**Consultation Response from KC,
Highways Development Management**
2025/92181 382, Huddersfield Road, Mirfield, WF14 9DL
Erection of extensions and raising of roof at front with front dormers
Date Responded: 19-11-2025.
Responding Officer: Mark Berry.
Responding Ref: 10-6SW-24.

This application seeks approval to the erection of extensions and raising of roof at front with front dormers at 382, Huddersfield Road, Mirfield

Proposed Site Plan
1 : 200

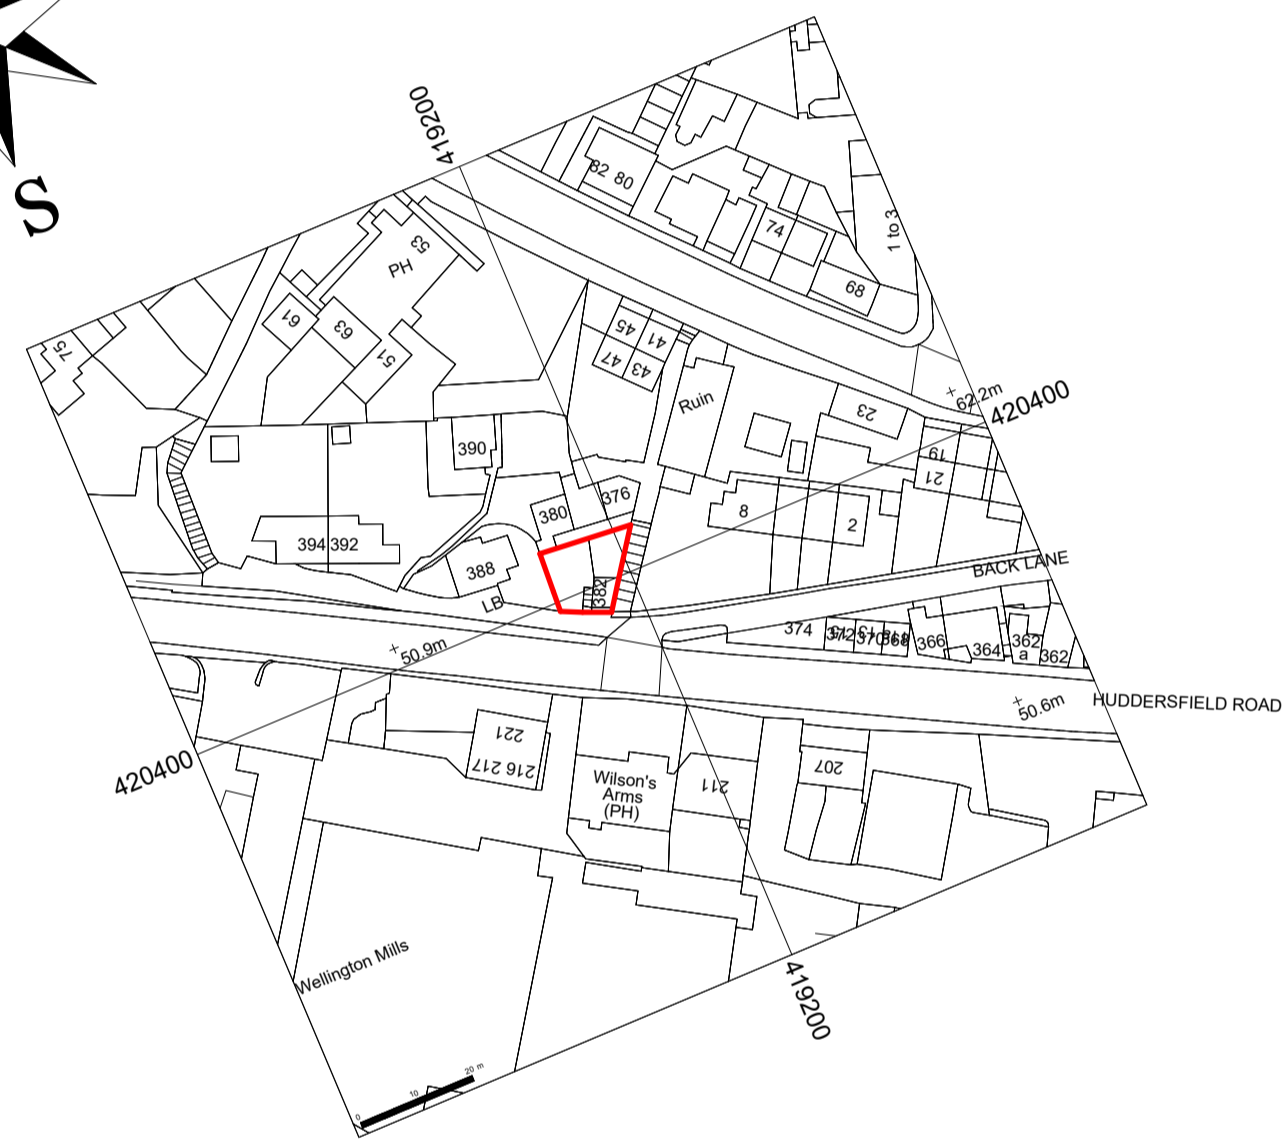
2, The proposals provide no off-street parking for staff, customers or service vehicles. Staff, customer and service vehicle parking is therefore likely to be on the main Huddersfield Road. On-street parking at this location is already likely to be at a premium given the other commercial uses opposite and at the junction and that nearby residential properties have no off-street parking.

3, The application provides no information regarding proposals for servicing of the proposed shop. Servicing is therefore likely to be from Huddersfield Road which is not considered to be in the best interests of highway safety.

Proposed Ground Floor Plan
1 : 50

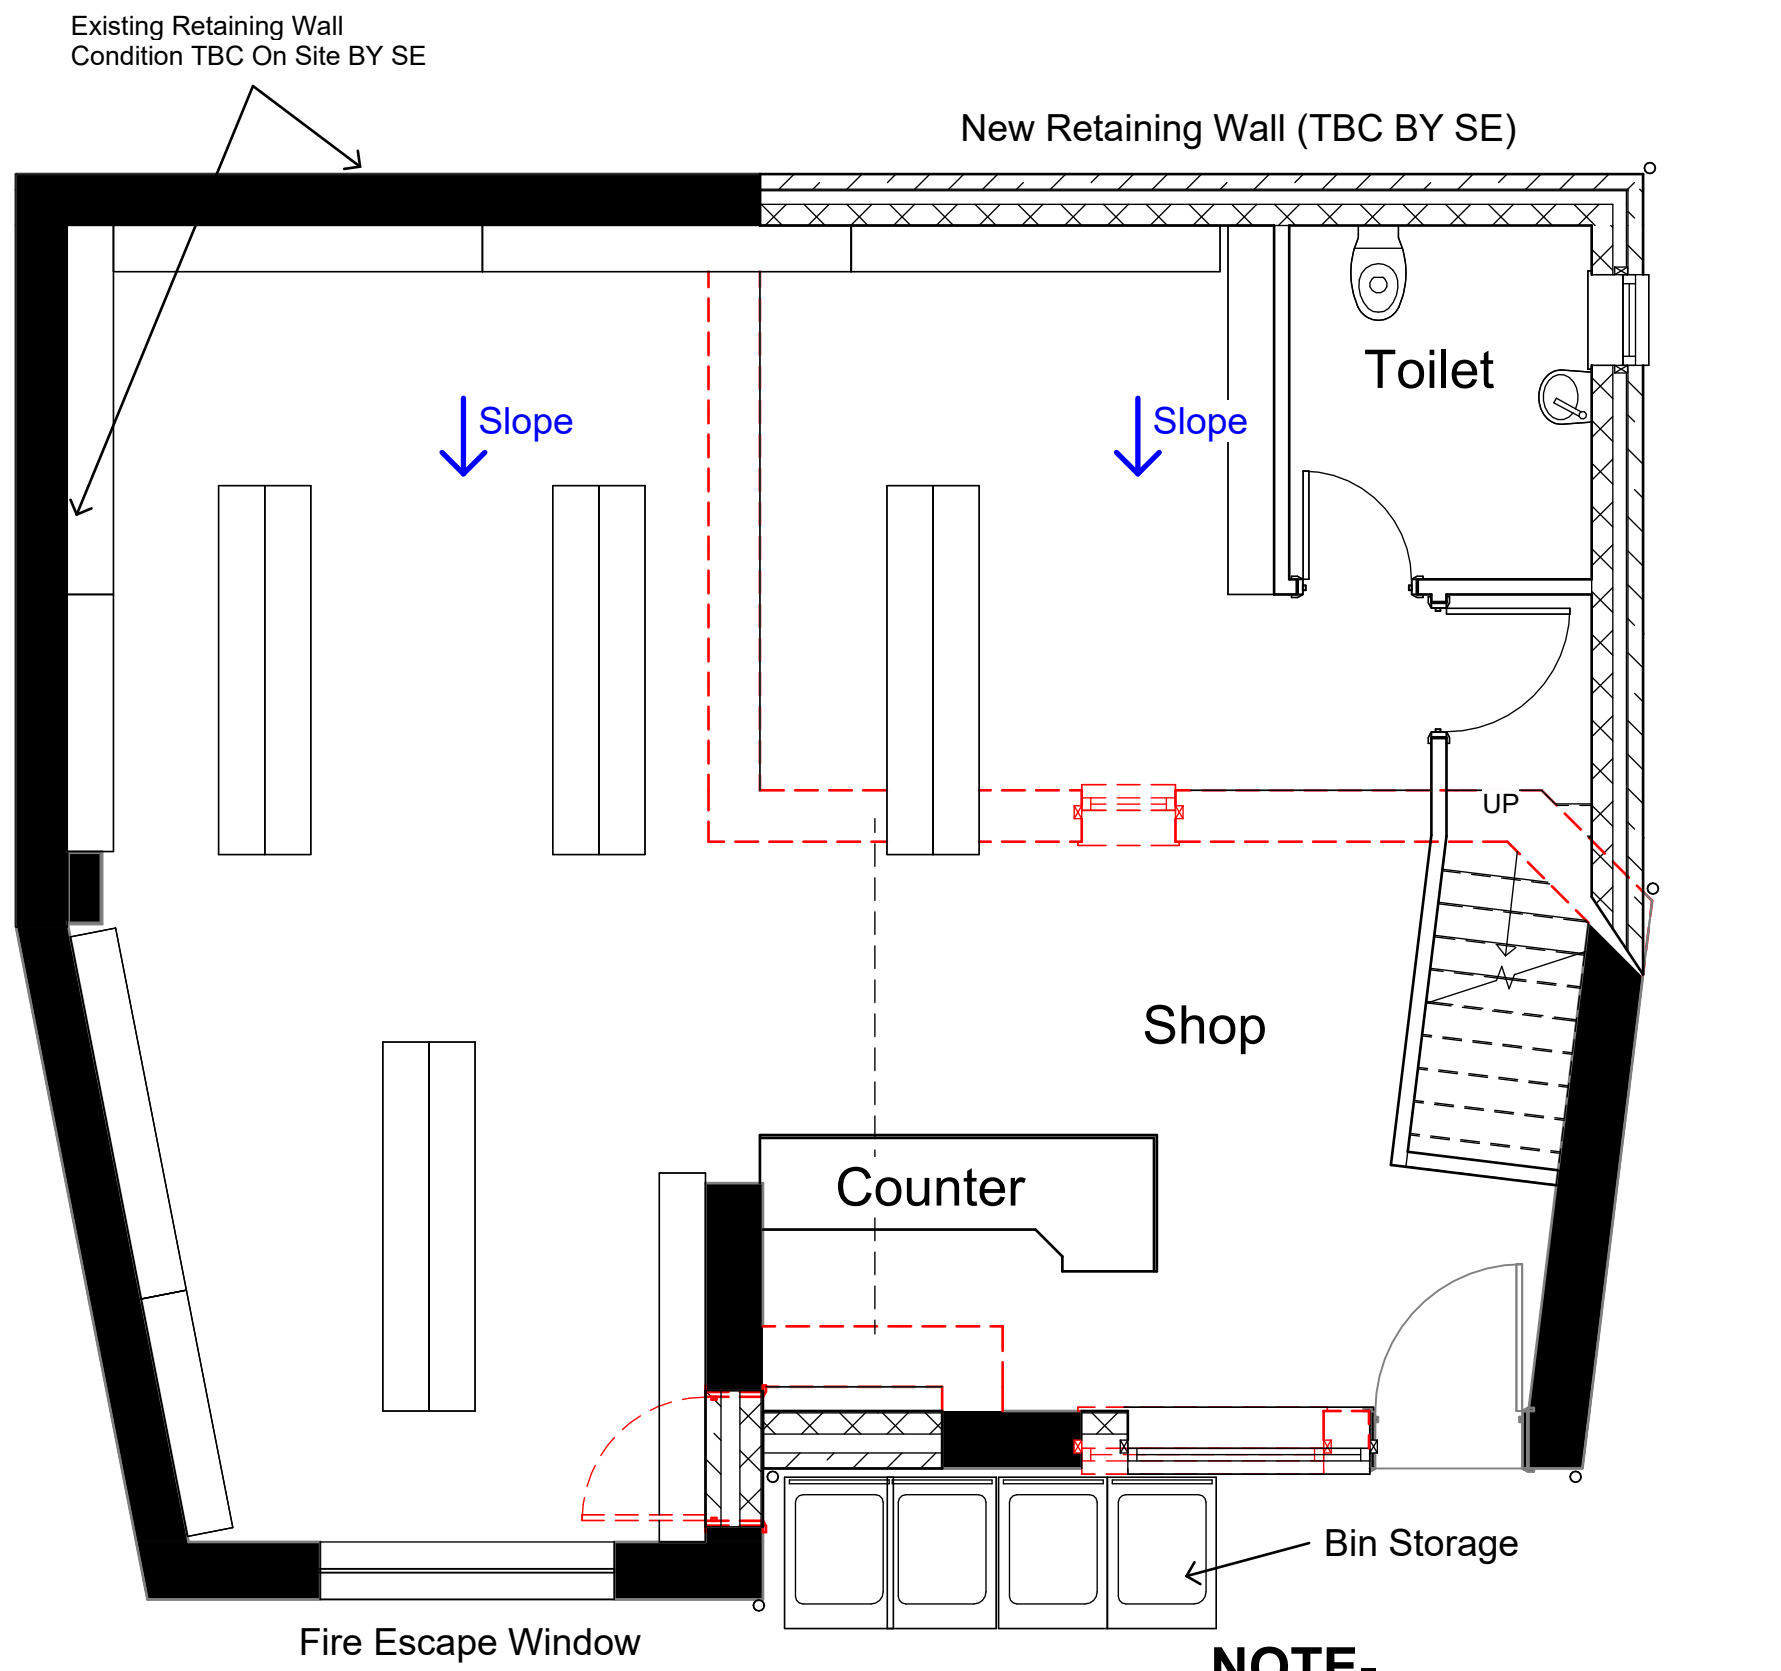
4, The Councils Waste Strategy section have confirmed that the proposed bin location is not acceptable and that it is likely that two x 1,100ltr bins will be required, one for recyclable waste and one for residual waste. Minimum floor space be per bin; 1,575mm x 1,190mm

These cannot realistically be stored as shown next to the proposed window and main entrance and

are therefore likely to be stored on the highway which is unacceptable.
